Tel: 01903 737756
Email: planning@arun.gov.uk
www.arun.gov.uk/planning
Please ask for: Laura Mills
Email: laura.mills@arun.gov.uk
Telephone: 01903737794
Our Ref: P/99/26/PL
Your Ref:
Date: 23rd July 2026

Application for Planning Permission

Development: Change of use of land from agricultural to recreational use for the siting of 10 holiday lodges for seasonal use (1 March-30 September) with associated groundworks, landscaping including retention of earth bund.
Location: Land North Of Lagnersh House Lower Bognor Road Lagness Chichester PO20 1LW

Drawing Block Plan

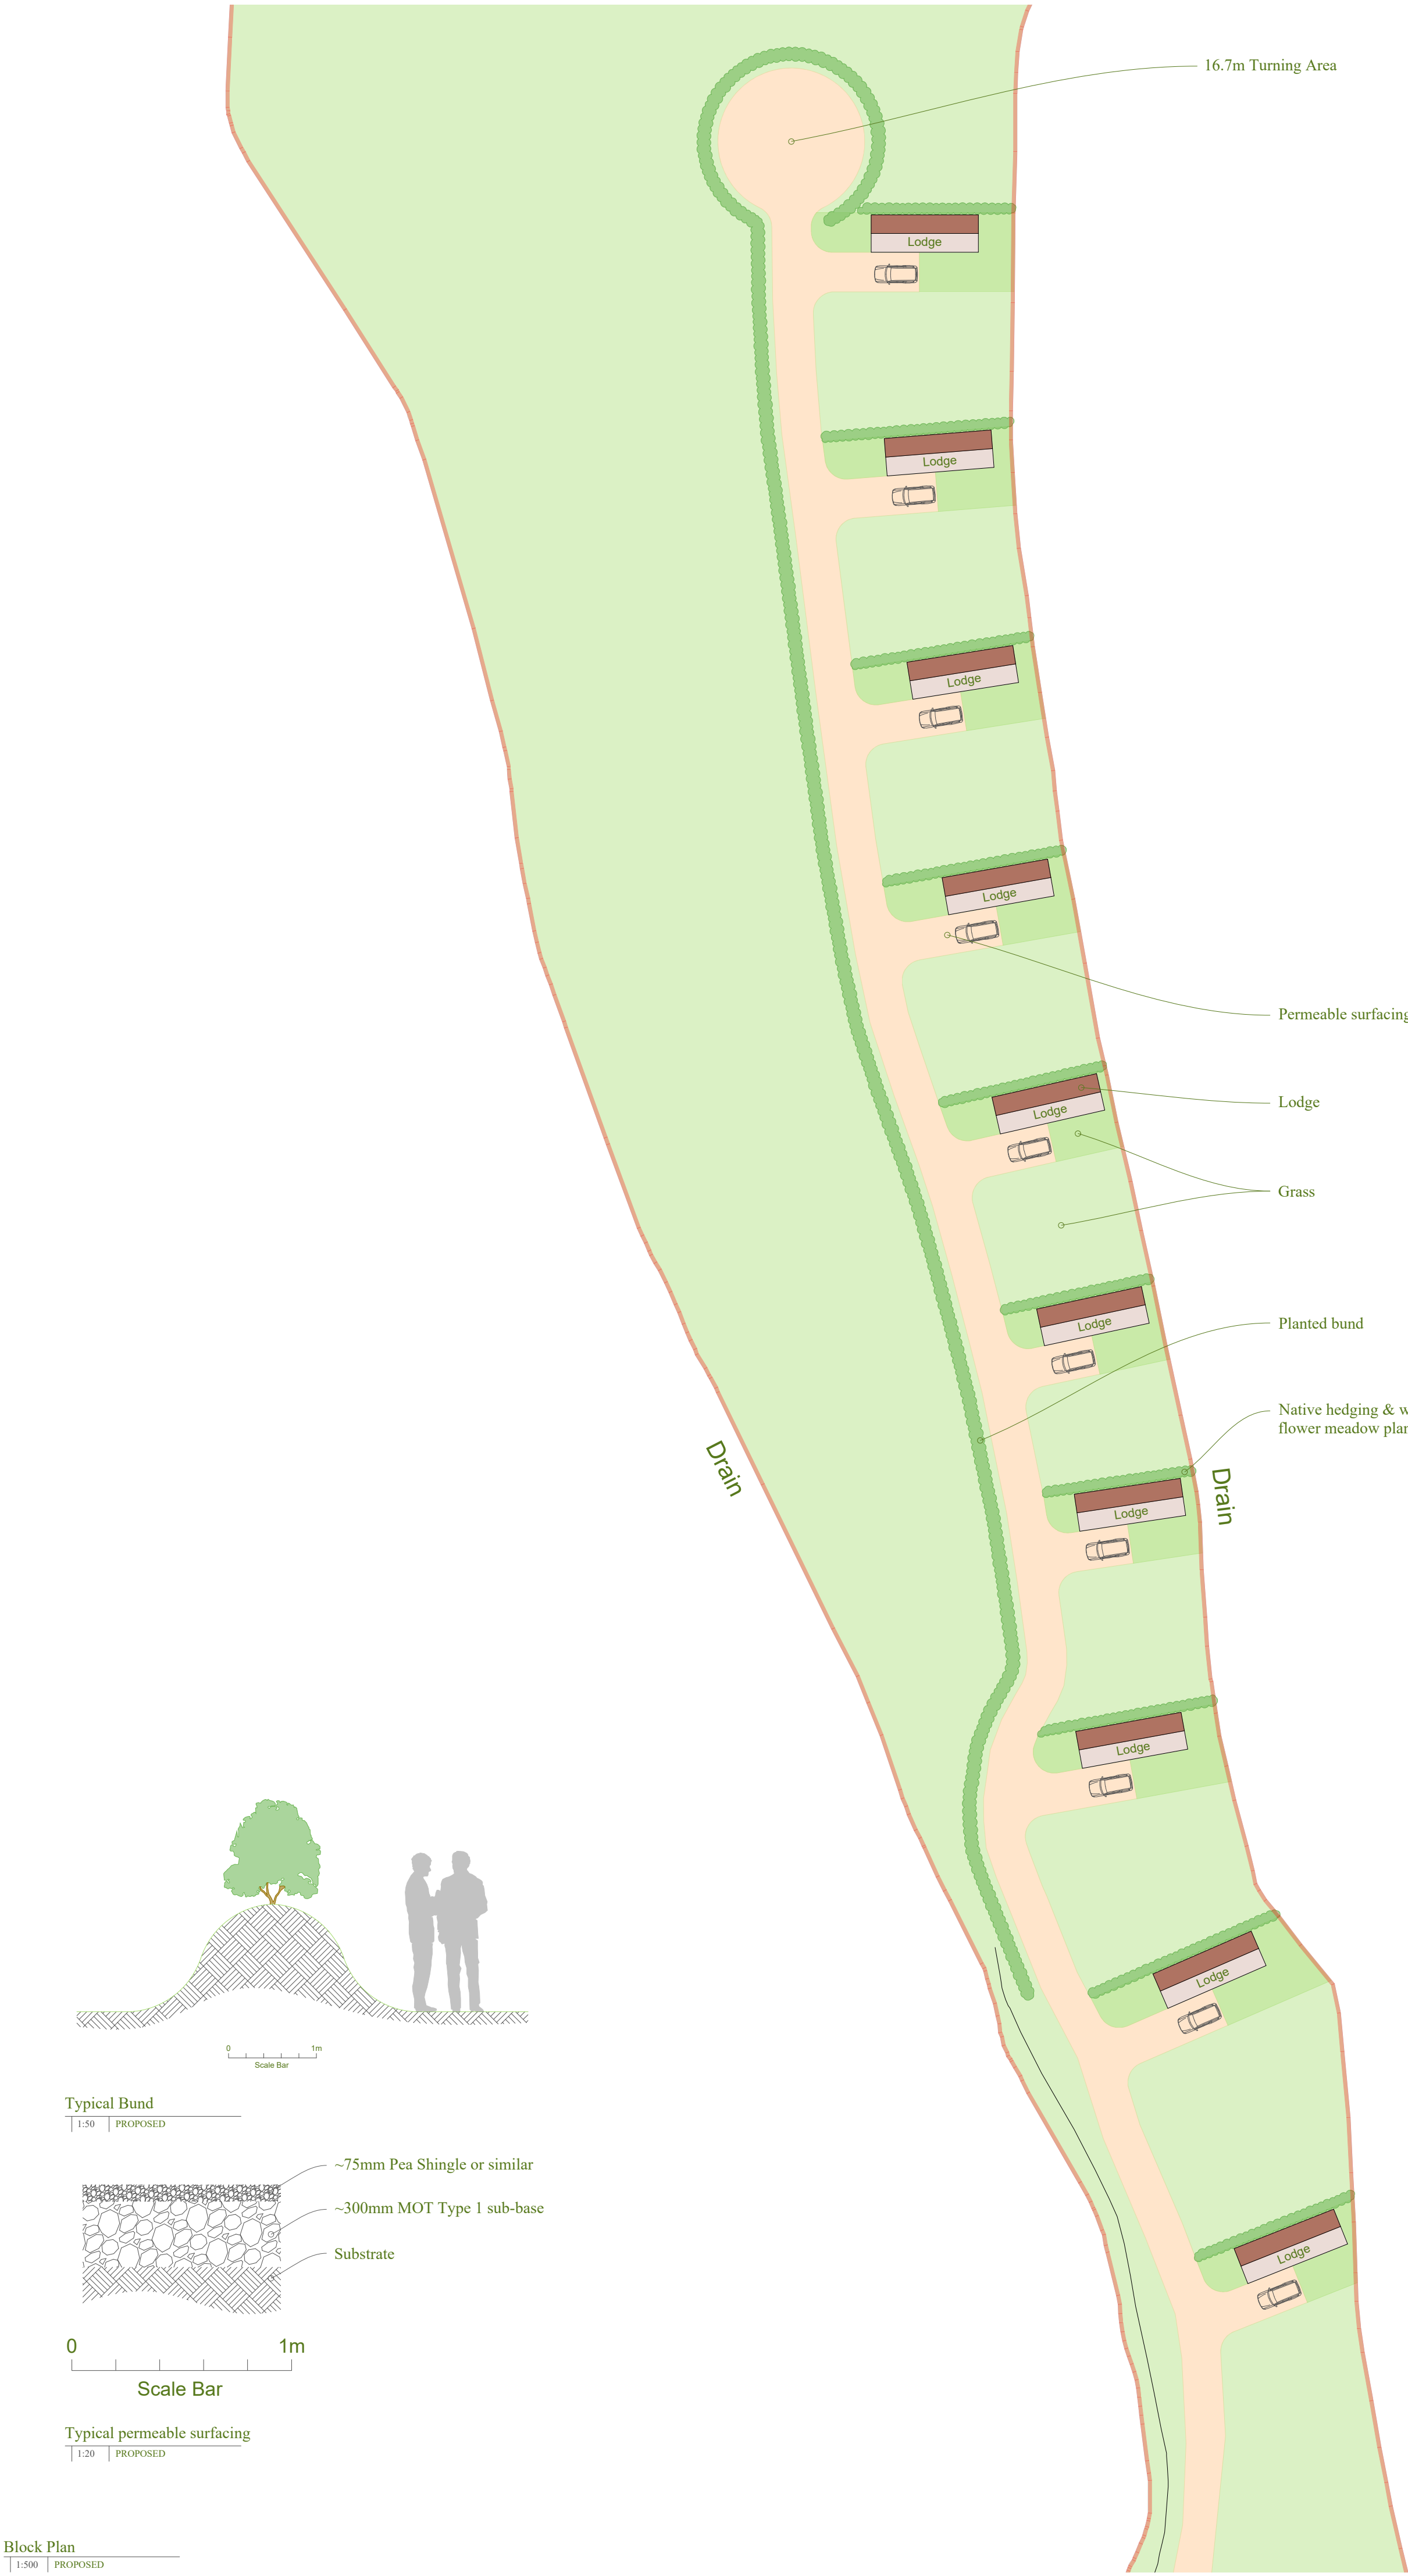
Block Plan

Please submit an electronic block plan in pdf format at a scale of 1:500, the current block plan submitted is 1:1250. Further details of what must be included on the plan can be found in the Validation Requirements List.

Proposed Caravan Plan & Elevations

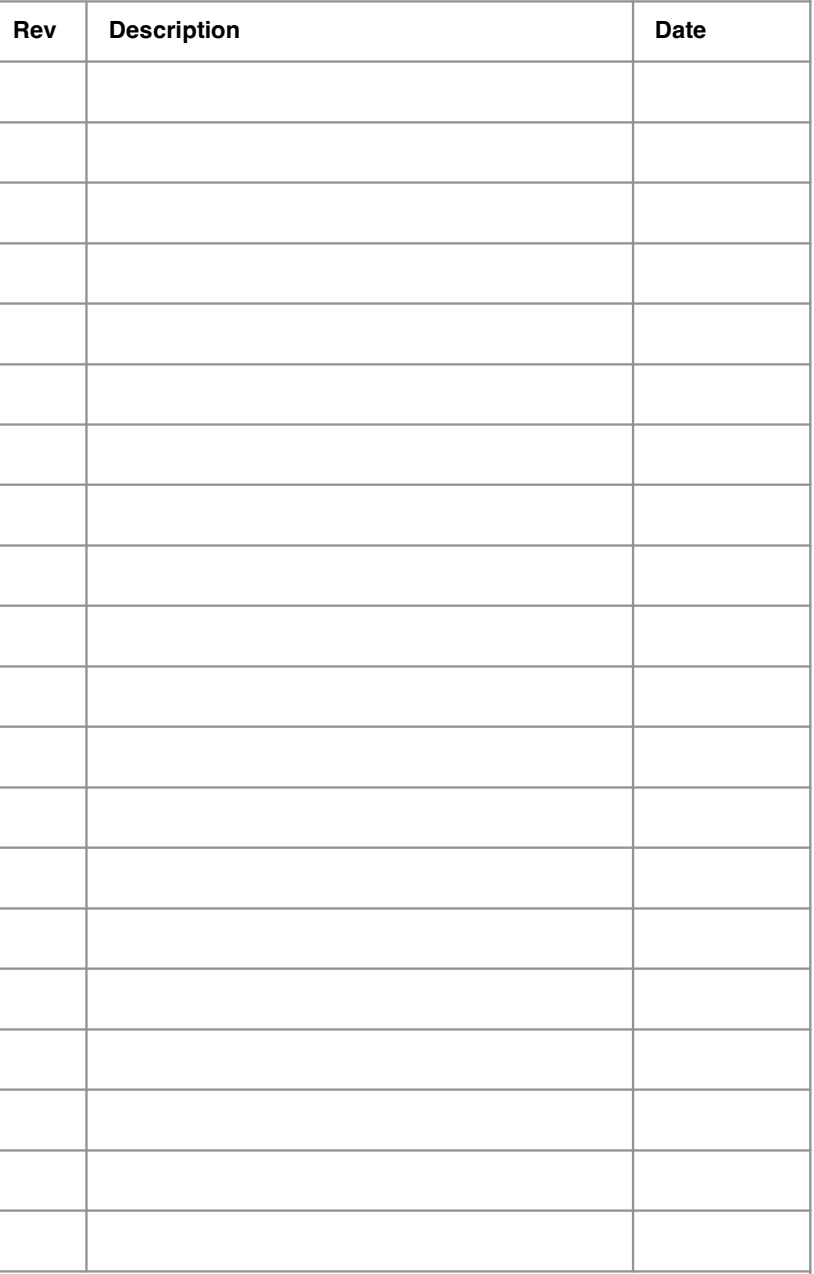
Elevations

Please submit electronic plans in pdf format clearly labelled proposed elevations for the holiday lodges at a scale of 1:50 or 1:100. Further details can be found in the Validation Requirements List.

Floor Plans

Please submit electronic plans in pdf format clearly labelled proposed floor plans for the holiday lodges at a scale of 1:50 or 1:100. Further details can be found in the Validation Requirements List.
